EPC STORMWATER REVIEW COMMENTS
 IN ORANGE BOXES WITH BLACK TEXT

Add "PCD File No. PPR2317"

WOODMOOR WSD NO. 1
 WELL NO. 22
 EL PASO COUNTY, COLORADO
 SITE DEVELOPMENT PLAN

SHEET NO.
FIG-1

SHEET NO.  
**FIG-1**

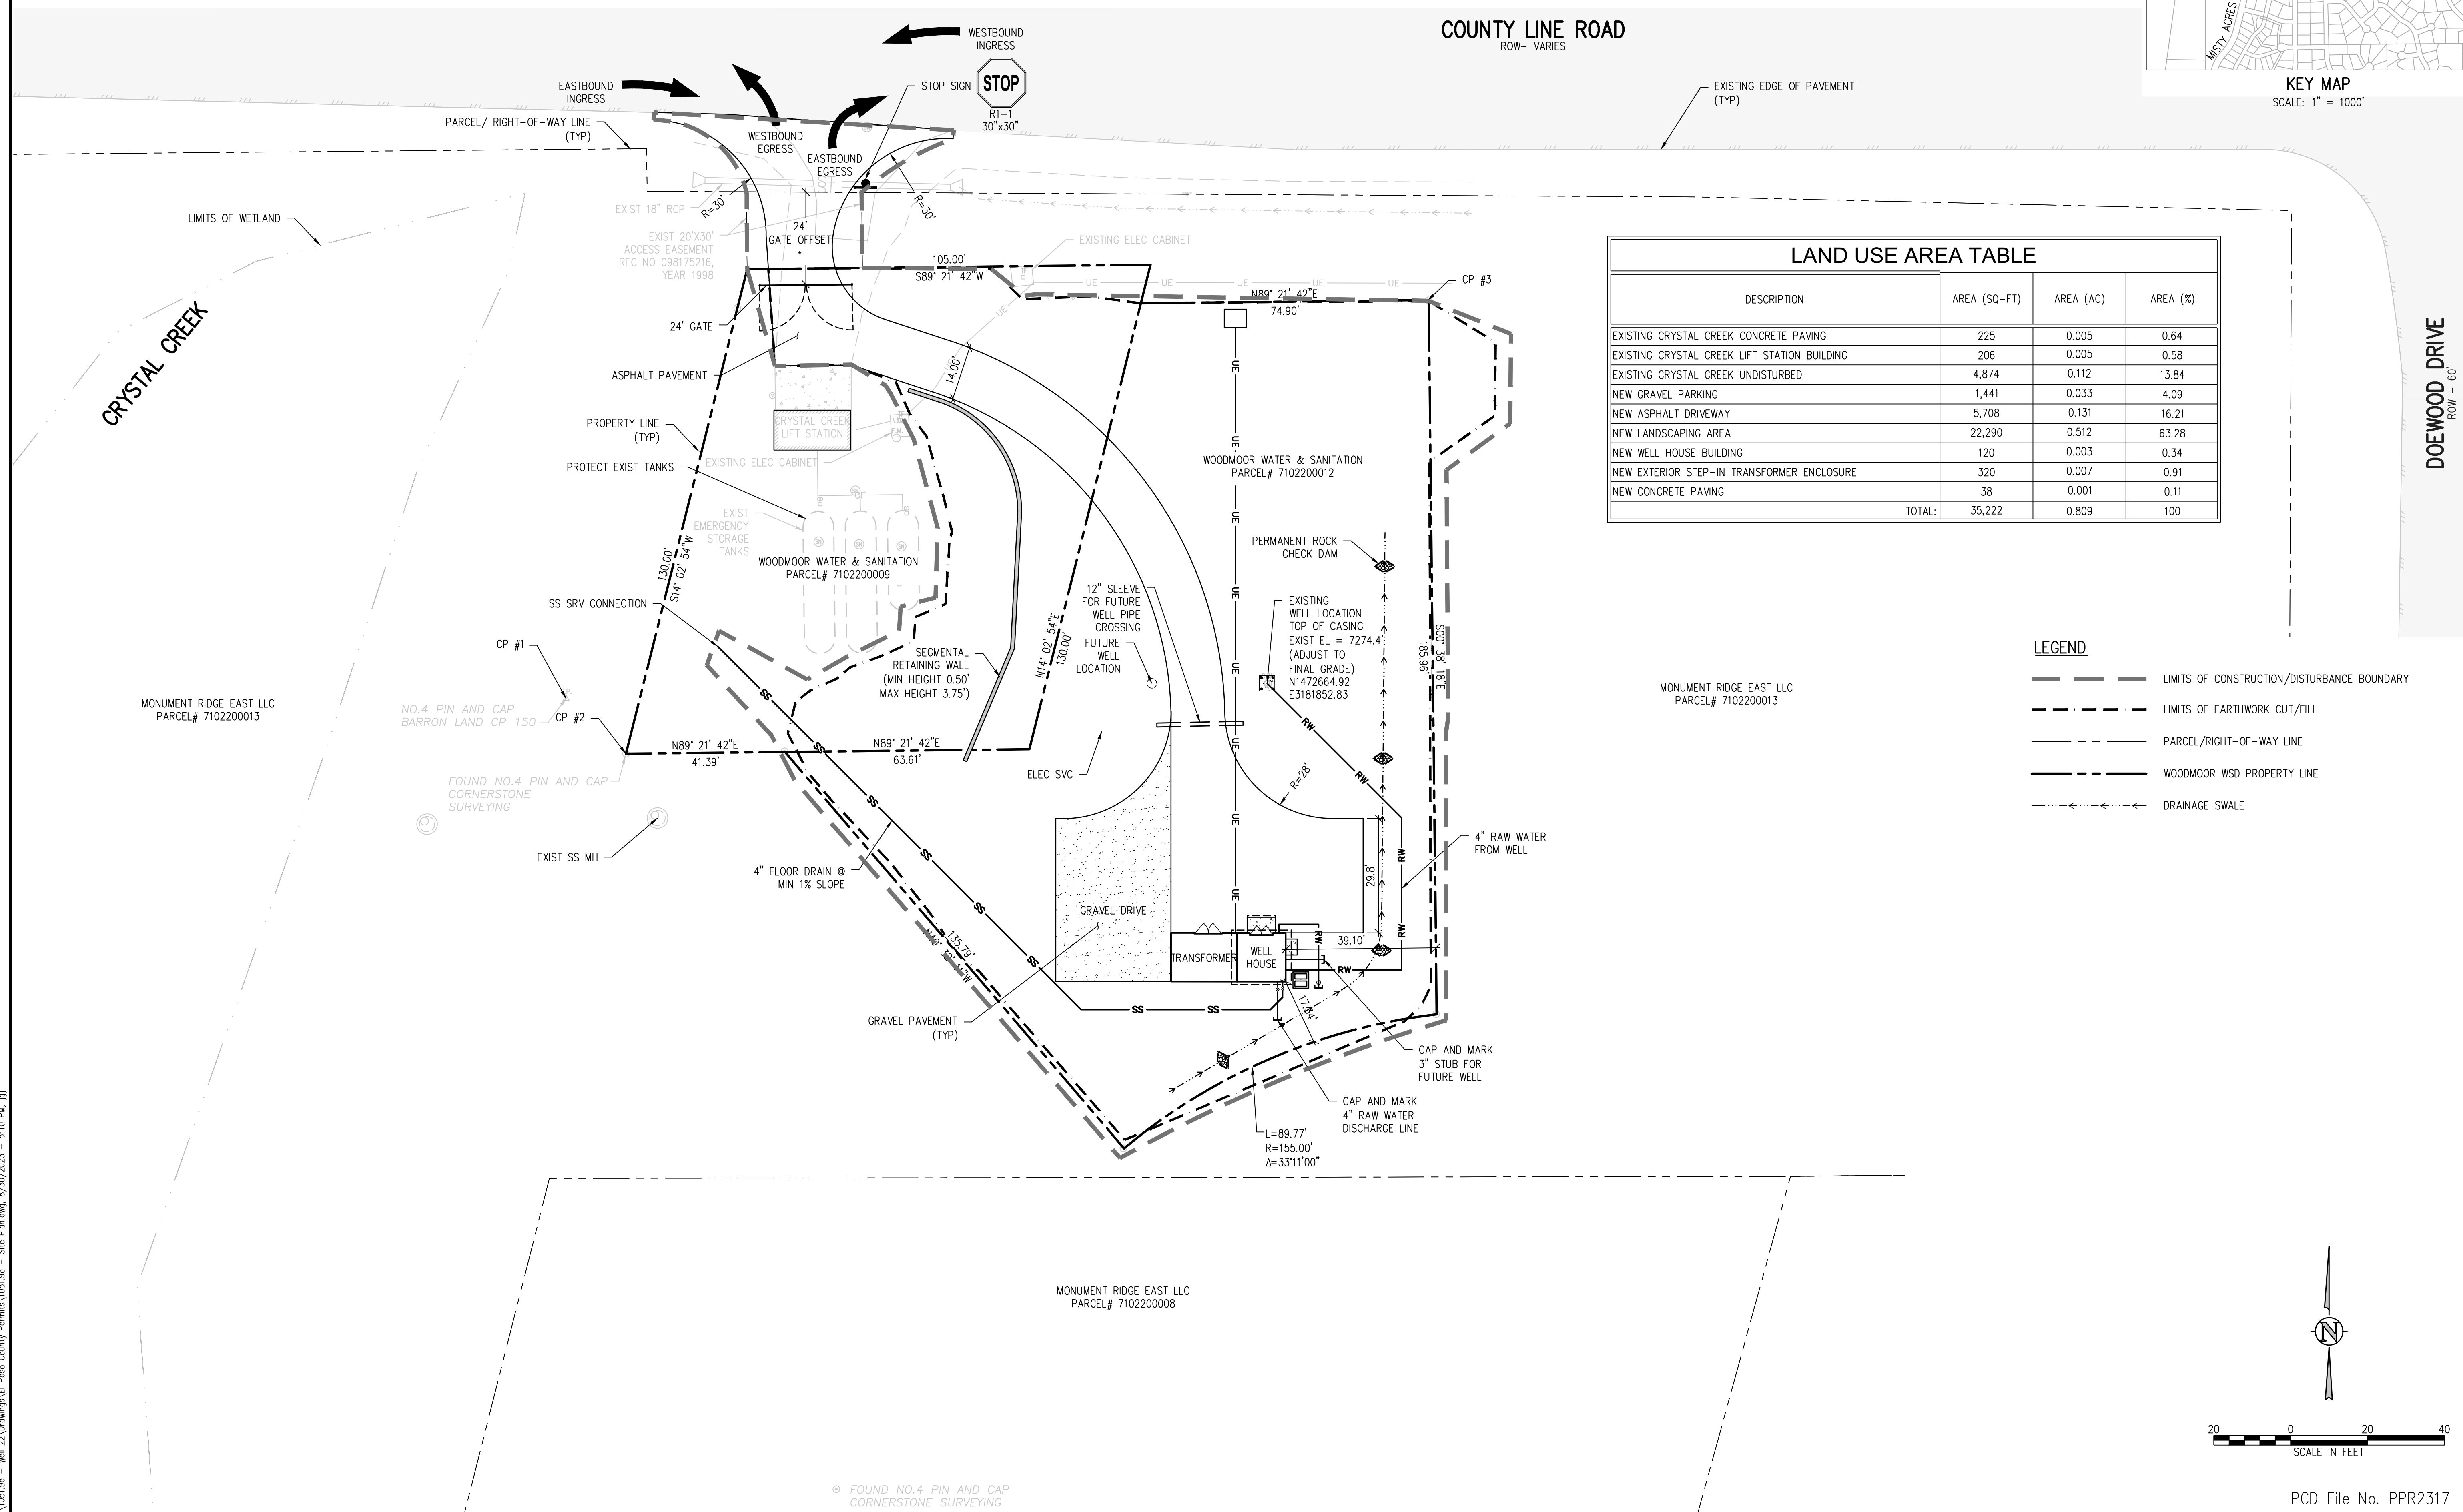
Please depict:
 -Traffic ingress/egress on property
 -Location and height of any fencing, walls, or berms
 -If there is signage:
 . location and dimensions
 - Lot area coverage percentage
 - Open space, landscaping, and impermeable surface percentage
 - Total gross building square footage

FYI:
 - A driveway access permit from El Paso County is required prior to construction and approval of a building permit.
